IMMINGHAM EASTERN RO-RO TERMINAL DCO APPLICATION

PINS REFERENCE TR030007

SUMMARY OF CASE MADE AT ISH1 BY DFDS

**IMMINGHAM EASTERN
 RO-RO TERMINAL
 LAYOUT OF PROPOSED
 MARINE WORKS**

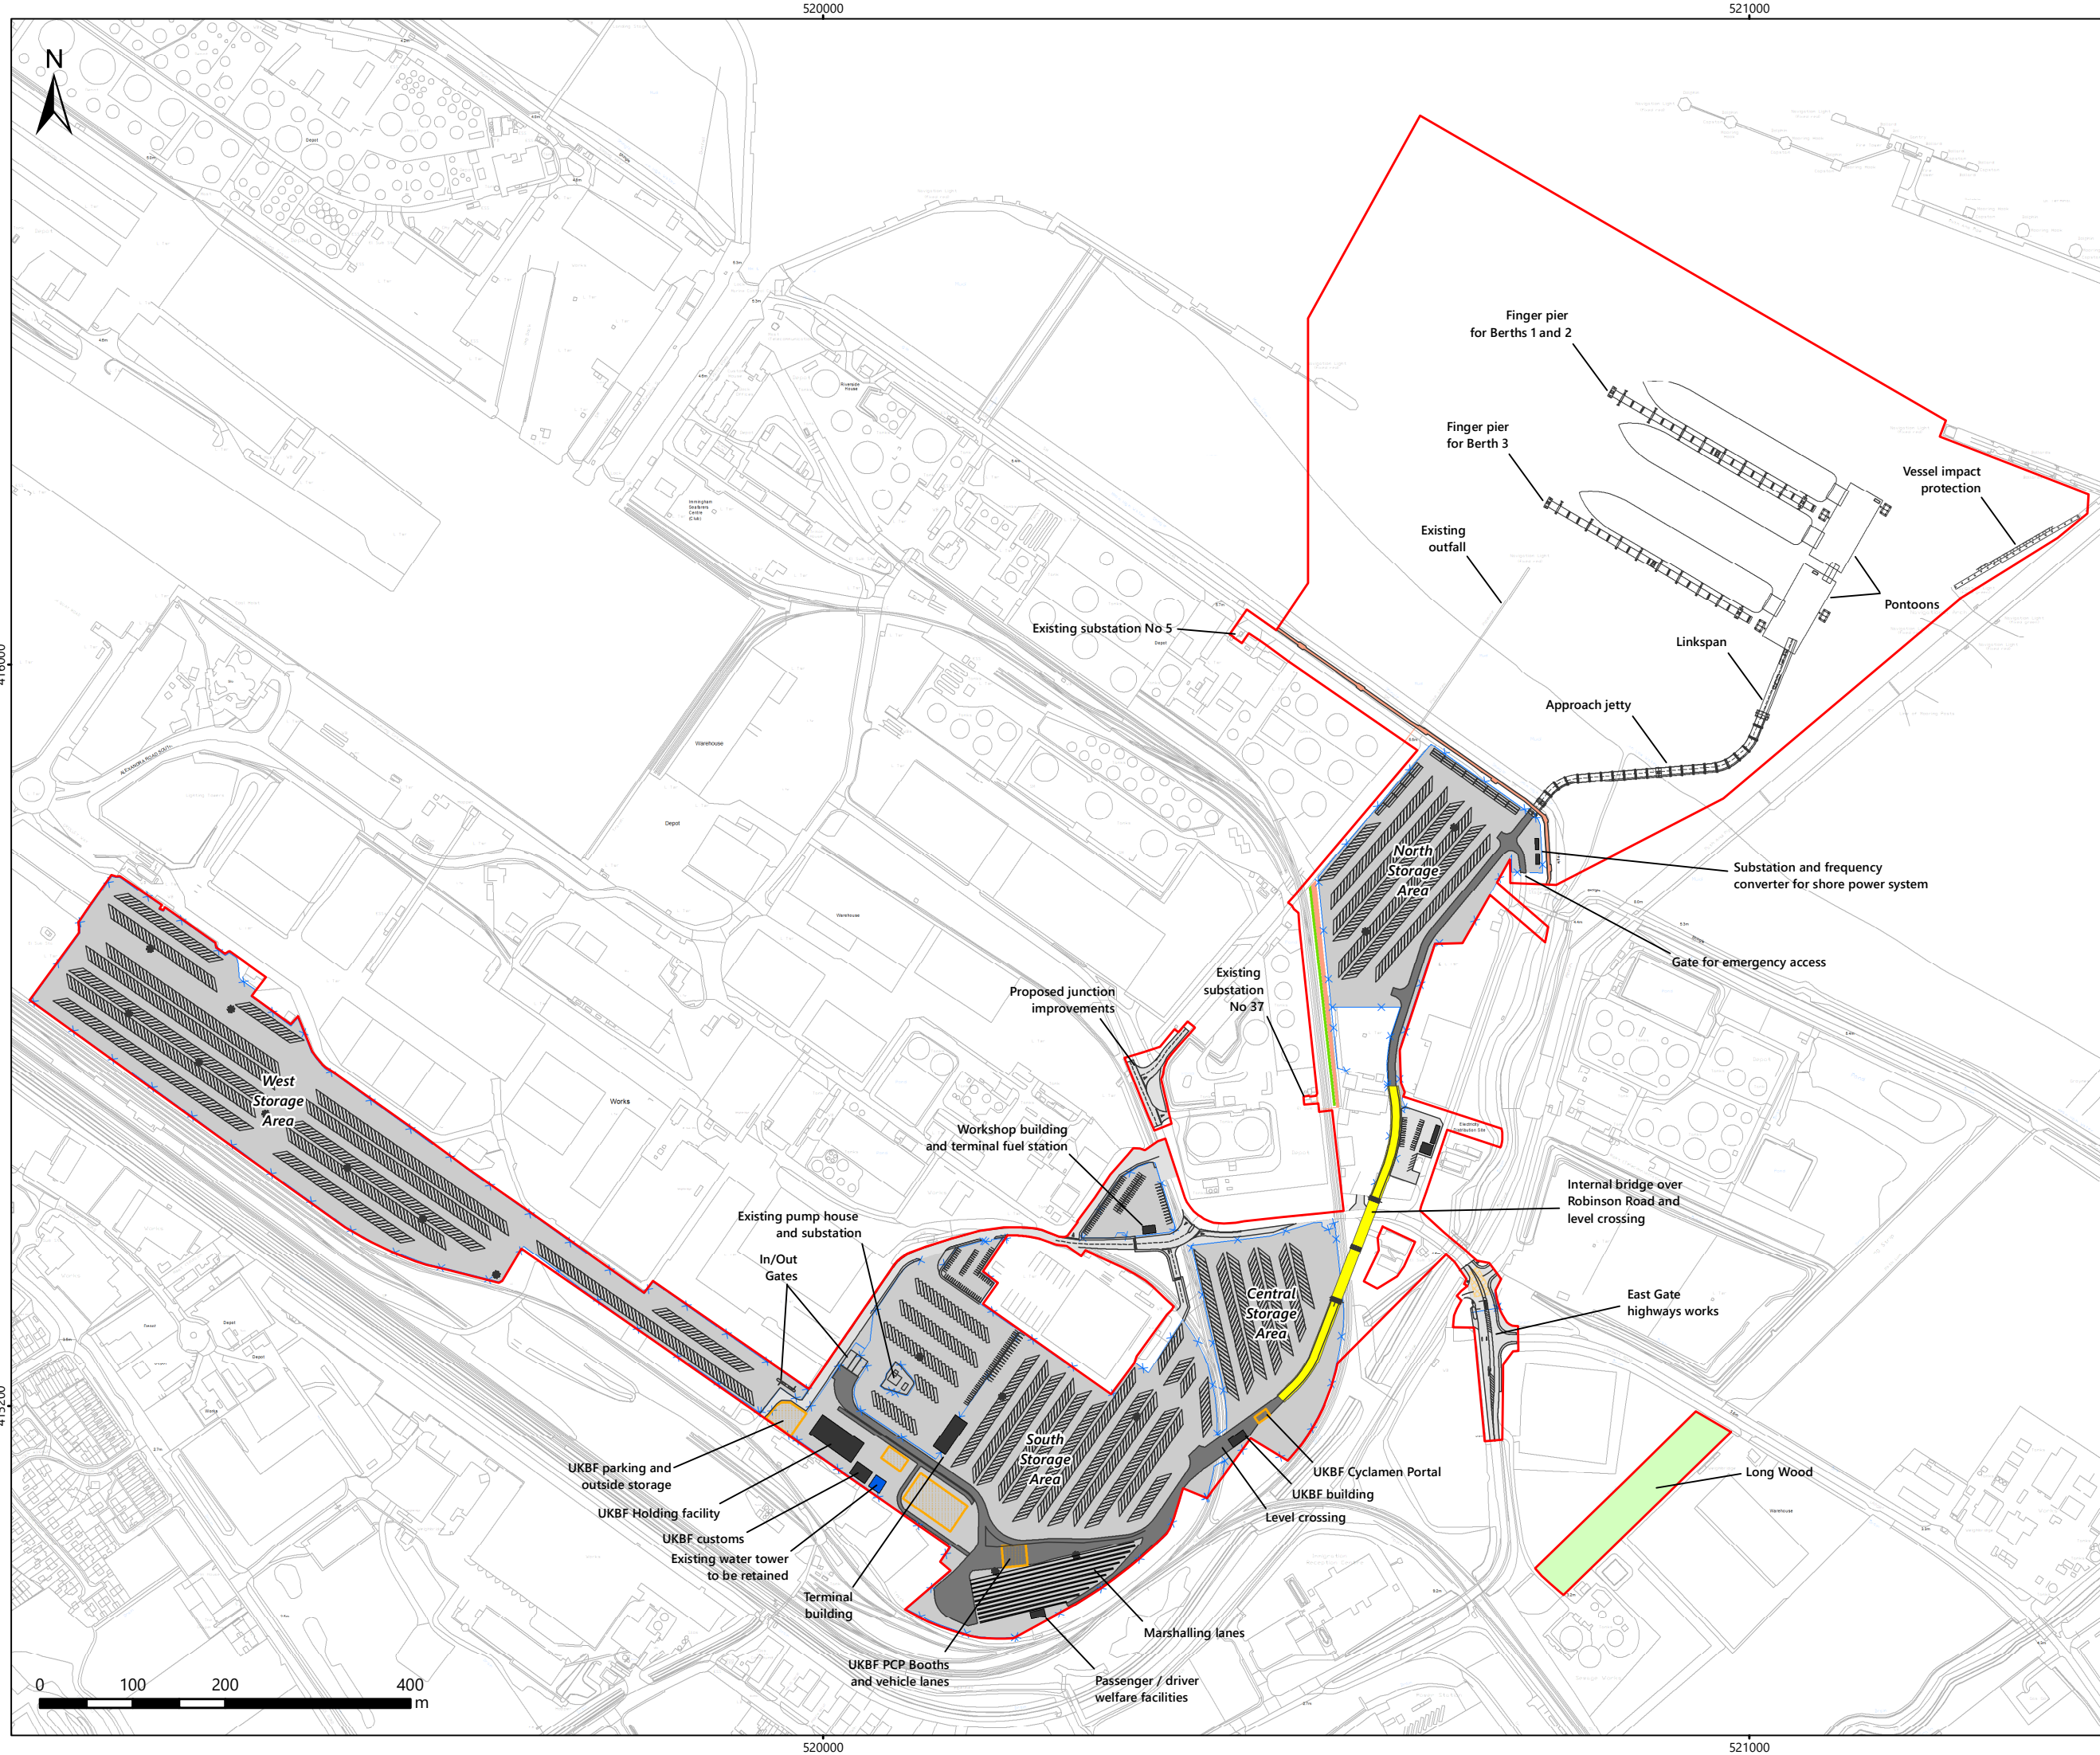
14. *DFDS considers that the area covered by Work No. 2 is too large for a dredge pocket for berthing at the new facilities, extending as it does all the way across to and including the end of the Eastern Jetty, and that the extent of Work No. 3 is too small as it does not protect the whole of the IOT finger pier nor all of the relevant part of the trunkway.*
